KIRKLEES METROPOLITAN COUNCIL INVESTMENT & REGENERATION SERVICE

DELEGATED DECISION TO DETERMINE PLANNING APPLICATIONS

Reference No:	2026/62/91720/W
Site Address:	1432, Manchester Road, Slaithwaite, Huddersfield, HD7 5JX
Description:	Alterations to convert single dwelling to two apartments and installation of solar panels to roof (within a Conservation Area)
Recommending Officer:	Joshua Merriman

Officer Report – 2026/91720

Ground Floor Flat 1
As Proposed (40m²)

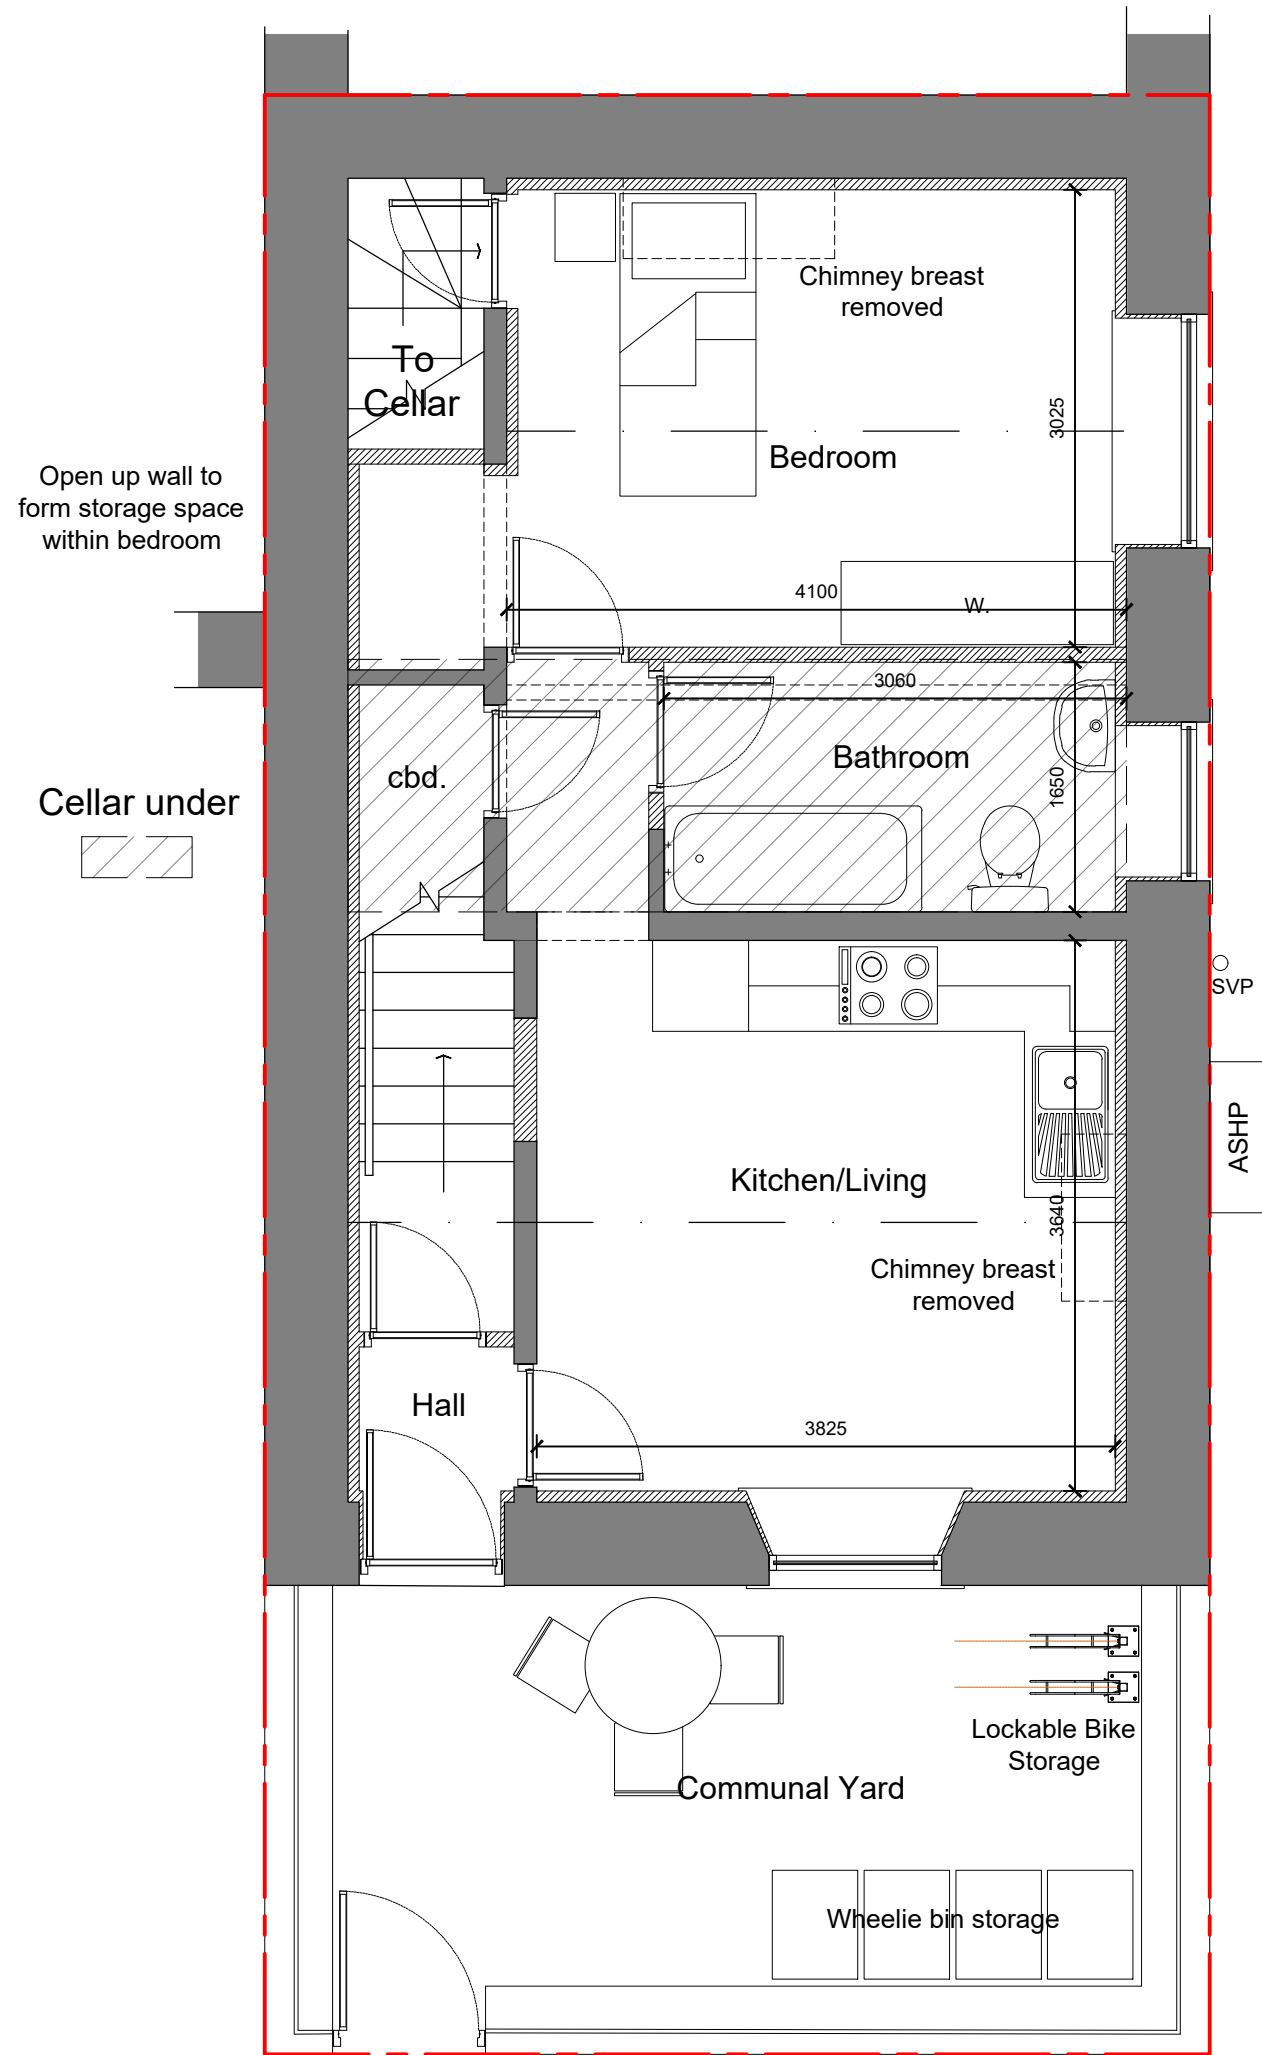
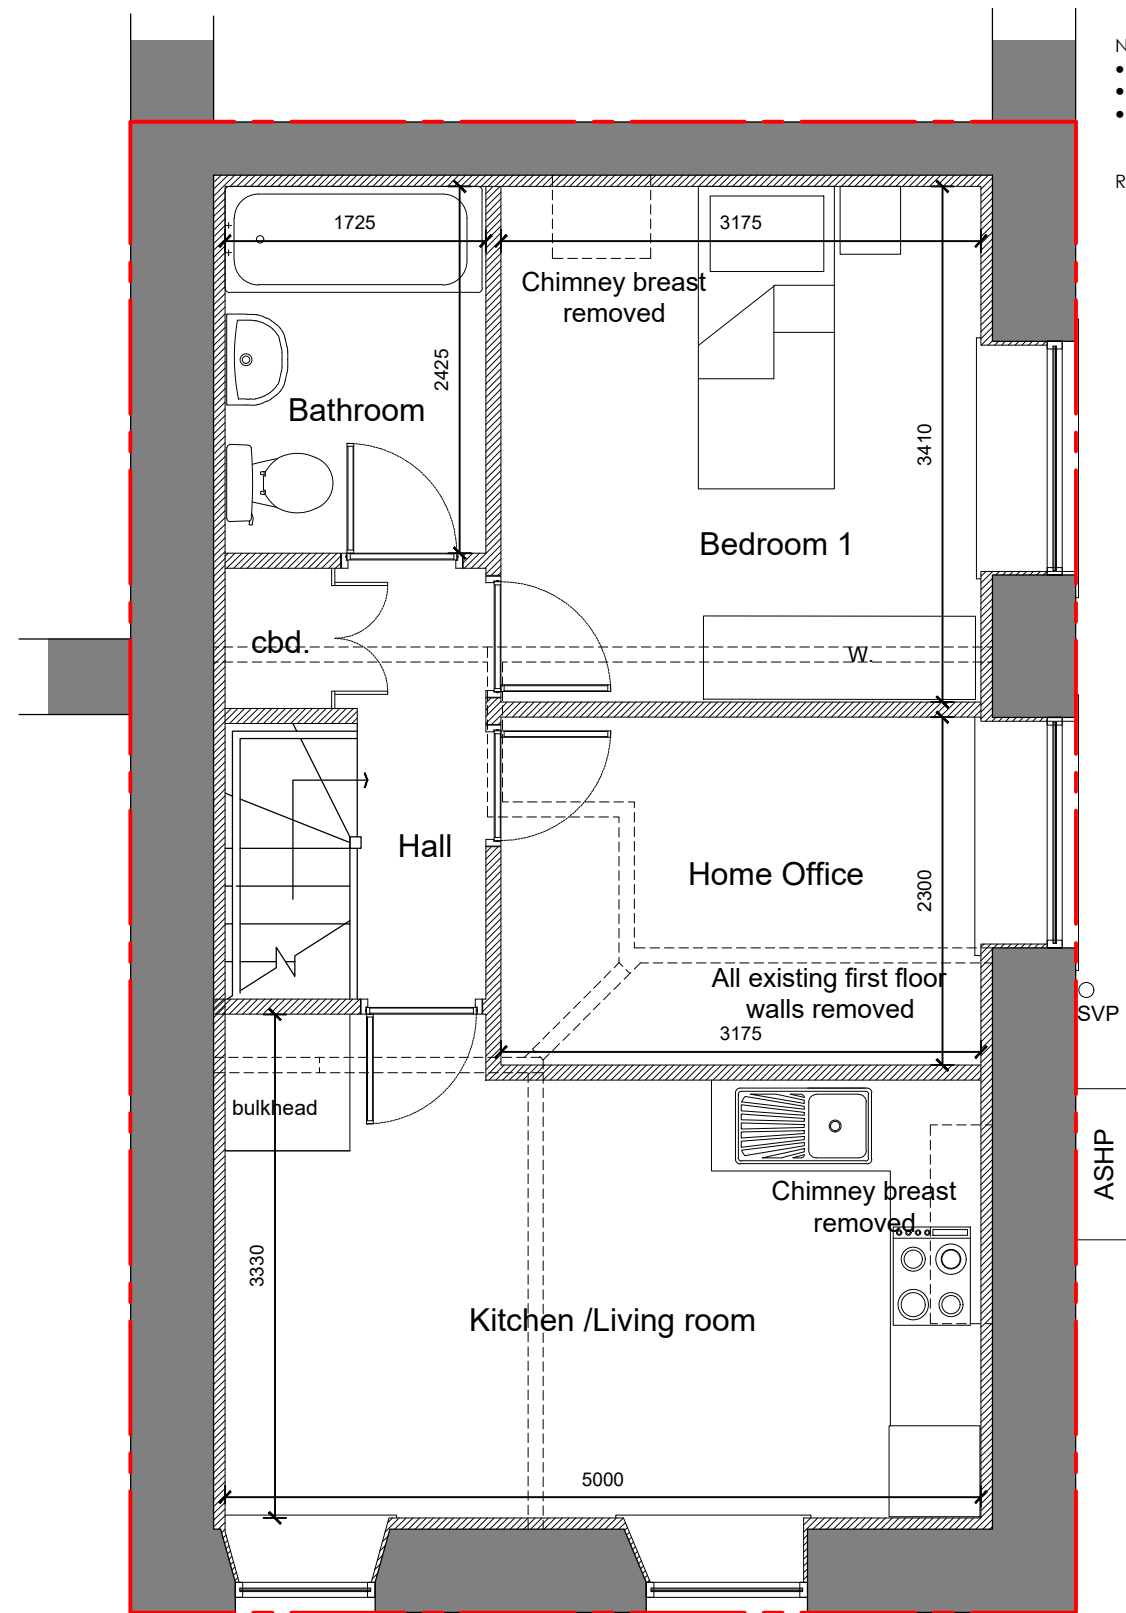
Officers requested updated, to scale, floor plans to ensure that both proposed units met National Described Space Standards as well as removing the singular proposed solar panel to the front elevation. Upon the receipt of these plans, it was confirmed that both apartments were compliant and acceptable in this manner.

With regard to Principle 16 of the Housebuilders SPD and the technical housing standards of the NDSS which outline that single storey dwellings with 1-bedroom require a total floorspace of 39m². This is not considered an issue for either apartment, as the total floor space of Flat 1 would be 40m², and the floorspace of Flat 2 would be 48.9m².

Roof Plan - As Proposed

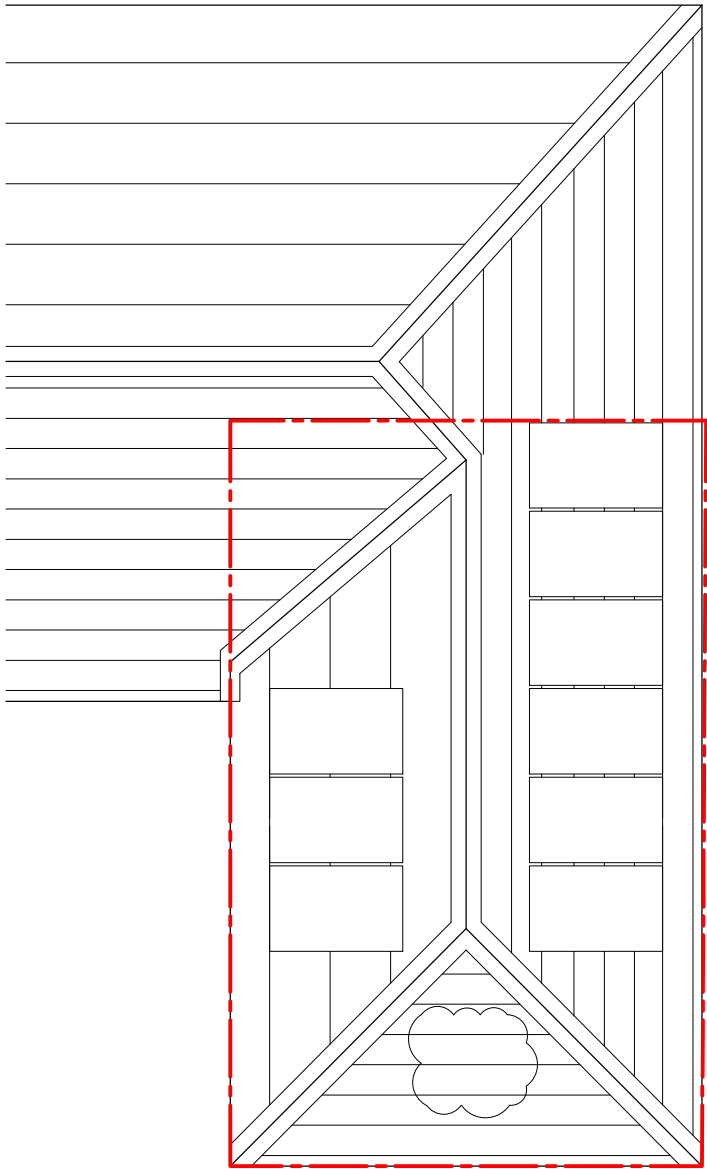
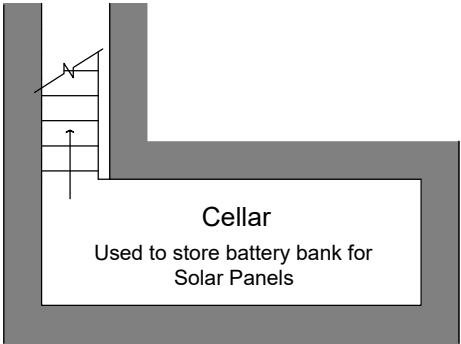
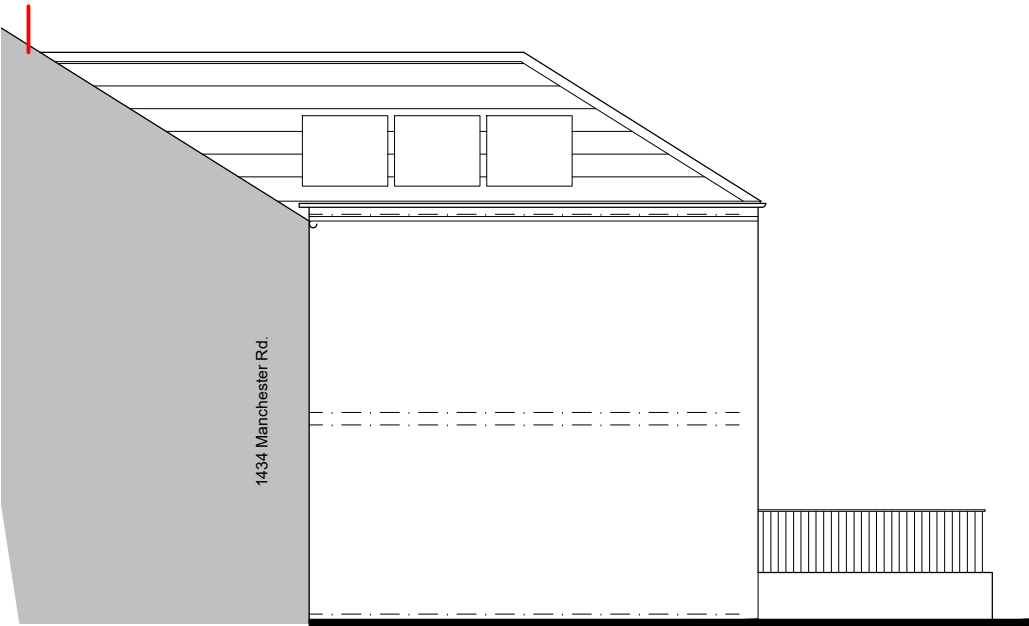
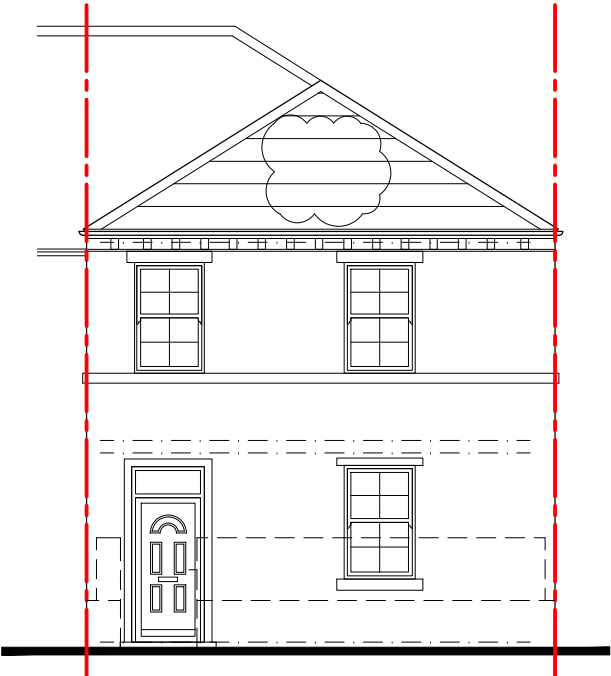
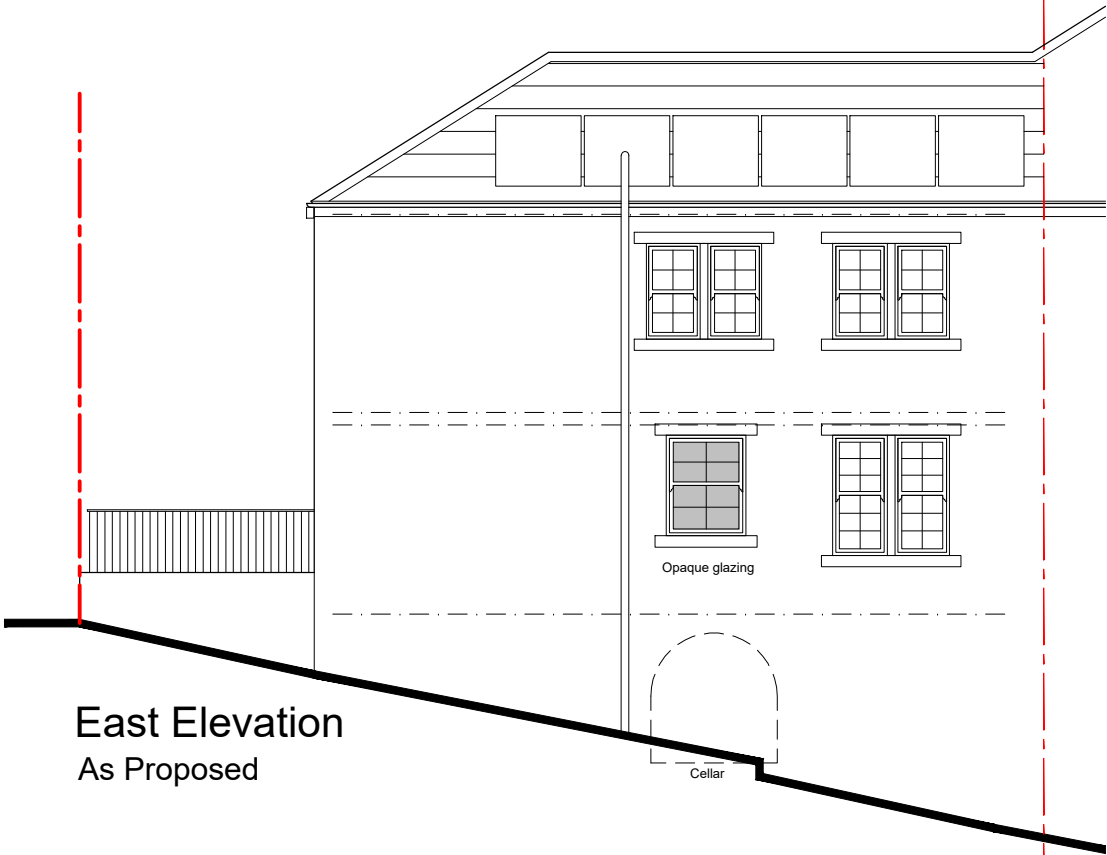
KC Conservation & Design (Informal) – No objections subject to the removal of the front solar panel.

As for the proposed solar panels, there is to be three units to the West elevation and six units to the East elevation. When viewing the dwelling from Manchester Road to the East, there is natural screening and neighbouring properties which prevent open views of the roof plane, with this only being viewed for a very small portion of the journey past the property. This is similar when viewing the dwelling from the West, as the neighbouring properties creating a courtyard type area to the front block any view of the application properties roof plane for a long period. Considering the above, and no objection from KC Conservation & Design, it is considered that the solar panels will not be significantly viewed from surrounding areas, and given the slightly mixed character of properties, and roofs, in the street scene, the proposed solar panels would cause no additional visual harm to the Slaithwaite Conservation Area. Moreover, given the benefits the property will derive from them, and how they will contribute to the Councils climate emergency, it is considered that on balance the solar panels are acceptable visually.

3. All solar panels on the property should be black in colour, with no silver linings, and should employ the use of a non-reflective coating.
